ADDENDUM PLANNING BOARD REPORT PORTLAND, MAINE

Residential townhouse - 6 unit condominium
133 York Street
Level III Site Plan and Subdivision
Project ID 2013-187
133 York, LLC, Applicant

Submitted to: Portland Planning Board Public Hearing Date: January 28 th , 2014	Prepared by: Jean Fraser, Planner Date: January 24 th , 2014 Addendum to Planning Board Report # 50-13
--	--

FRONT VIEW

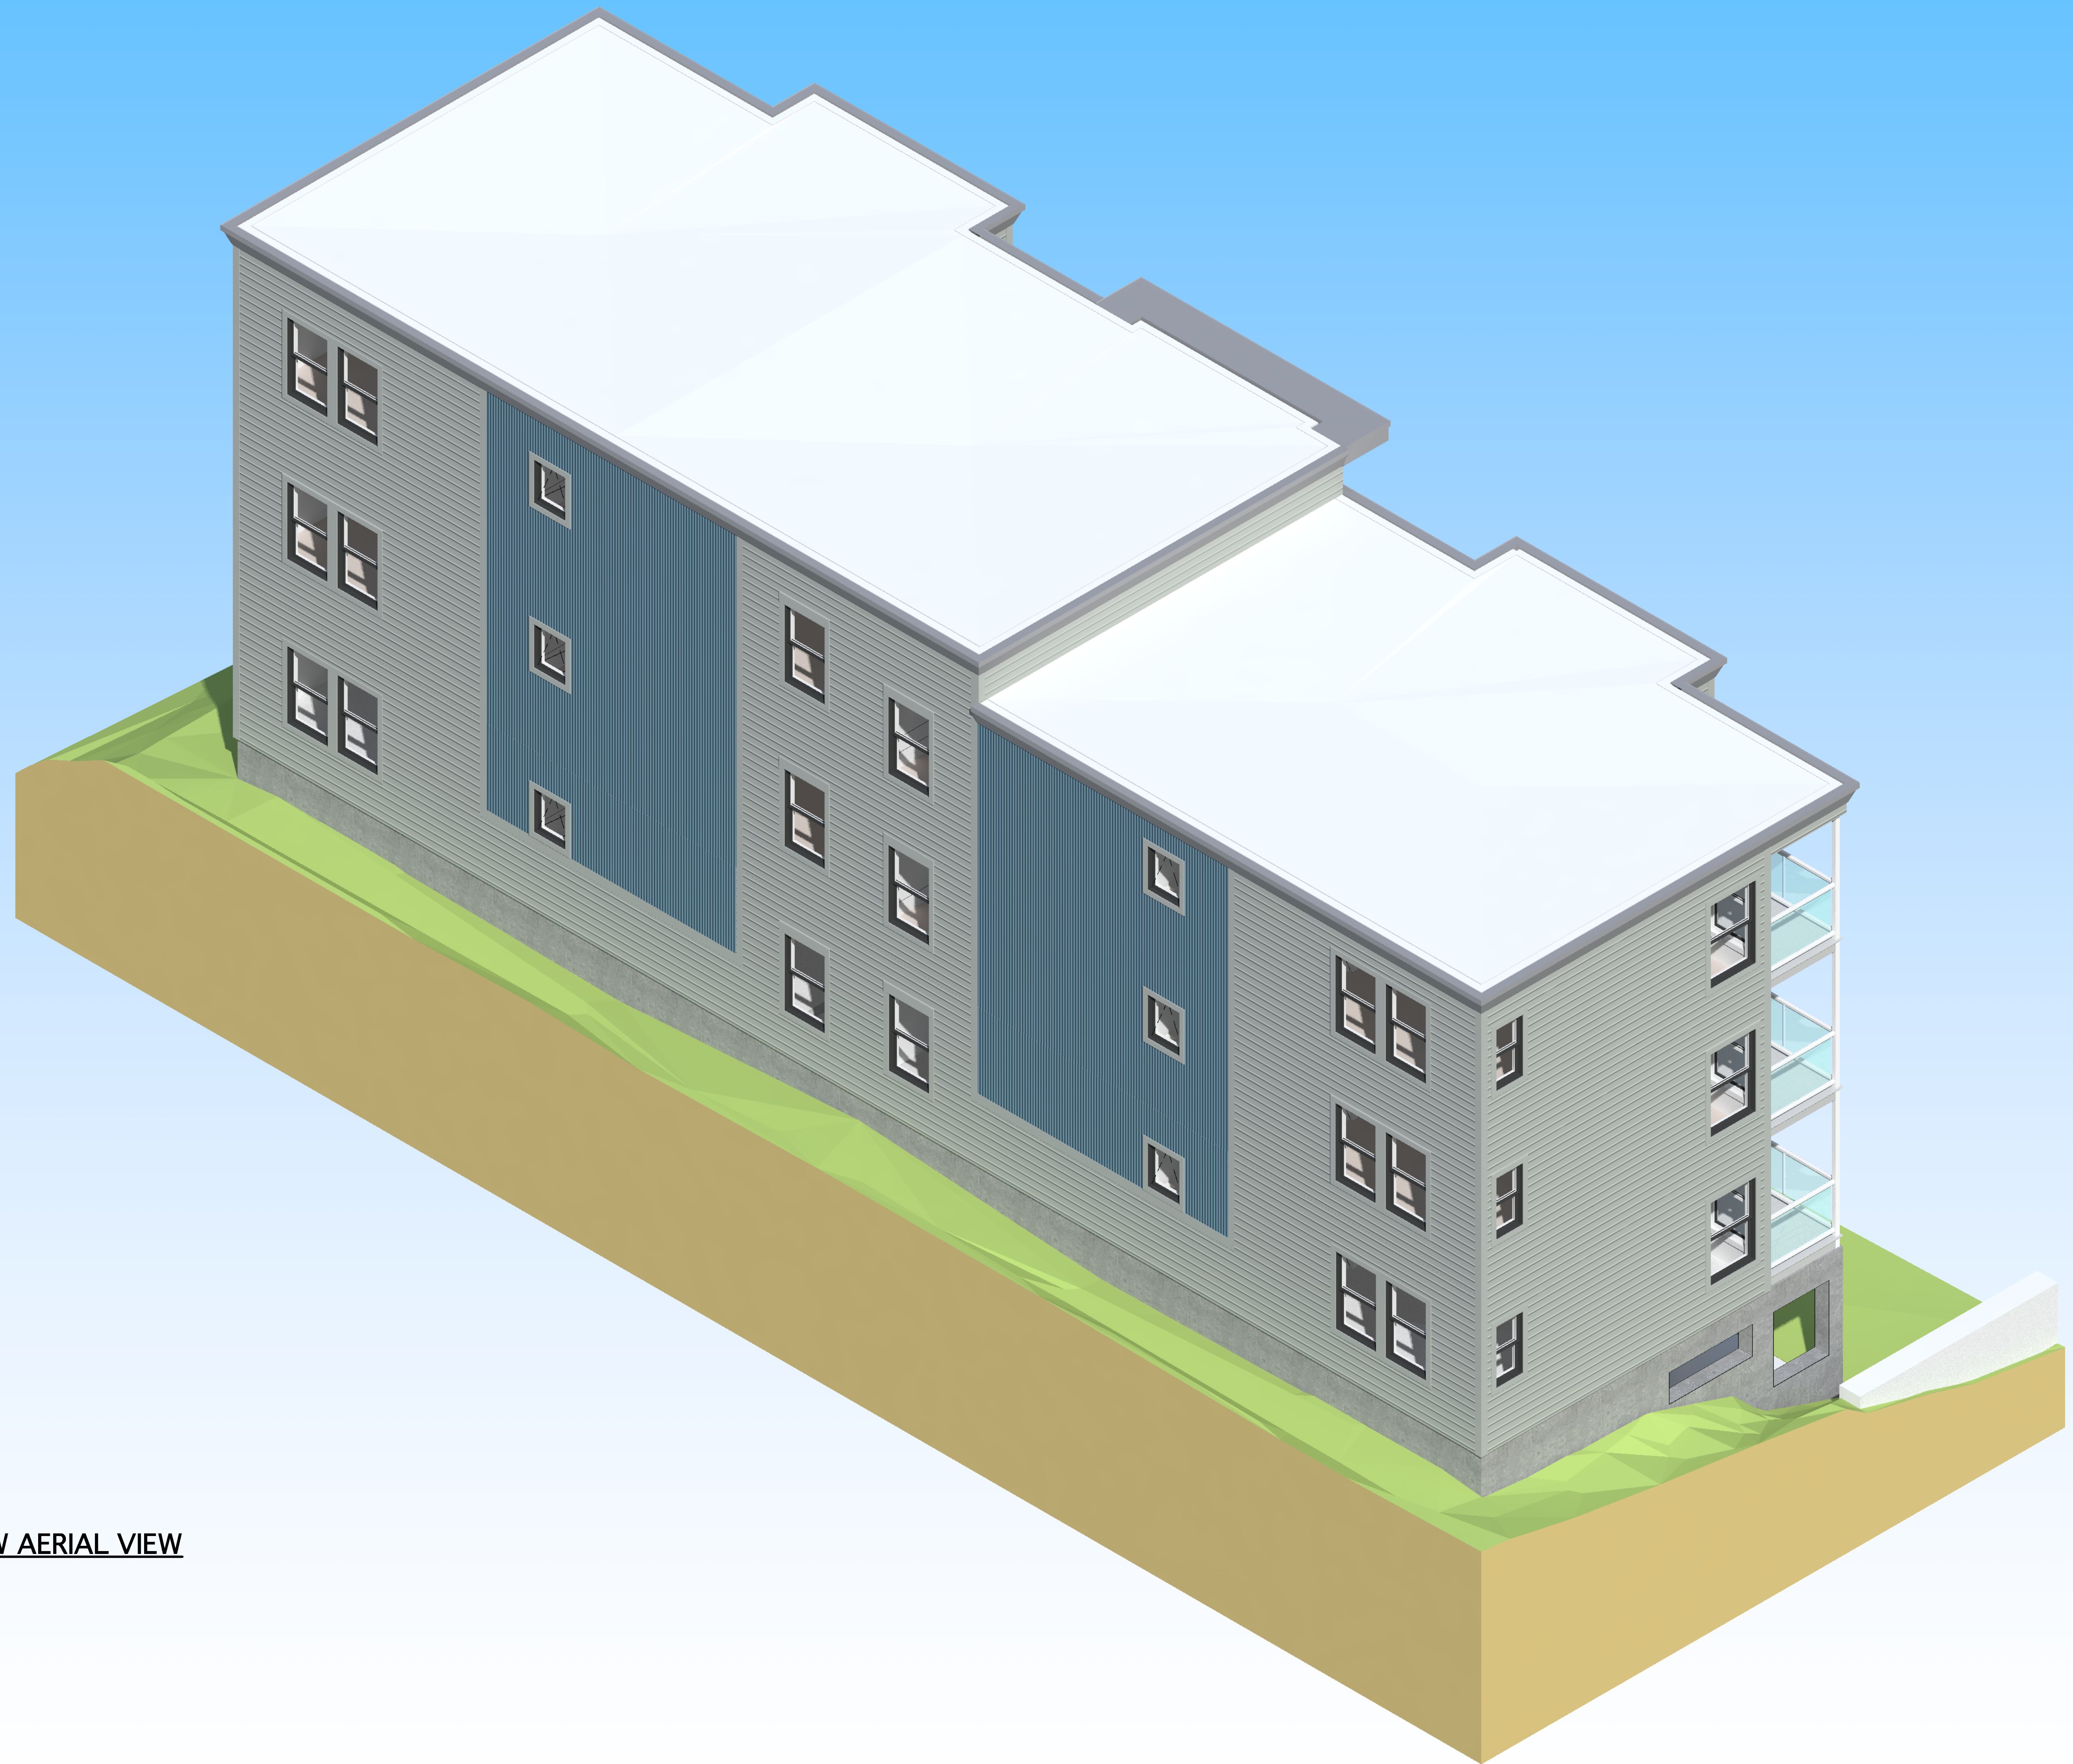
Staff do not have any serious concerns regarding the final design, but request three minor revisions to refine the latest design:

- The tone of the entire central entrance section should be somewhat darker to contrast with the abutting material;
- The overlarge and angled central cornice area should be simplified so it relates to the canopy over the entrance door and better ties into the roof line; and
- Lighting (downlighting) from underneath the entrance canopy should be added.

- i. That the applicant shall submit a revised front elevation to address the Design Review comments dated 1.23.2014 concerning tone of material, integration of the cornice, and lighting under the entrance canopy, for review and approval by the Planning Authority prior to the issuance of a building permit; and
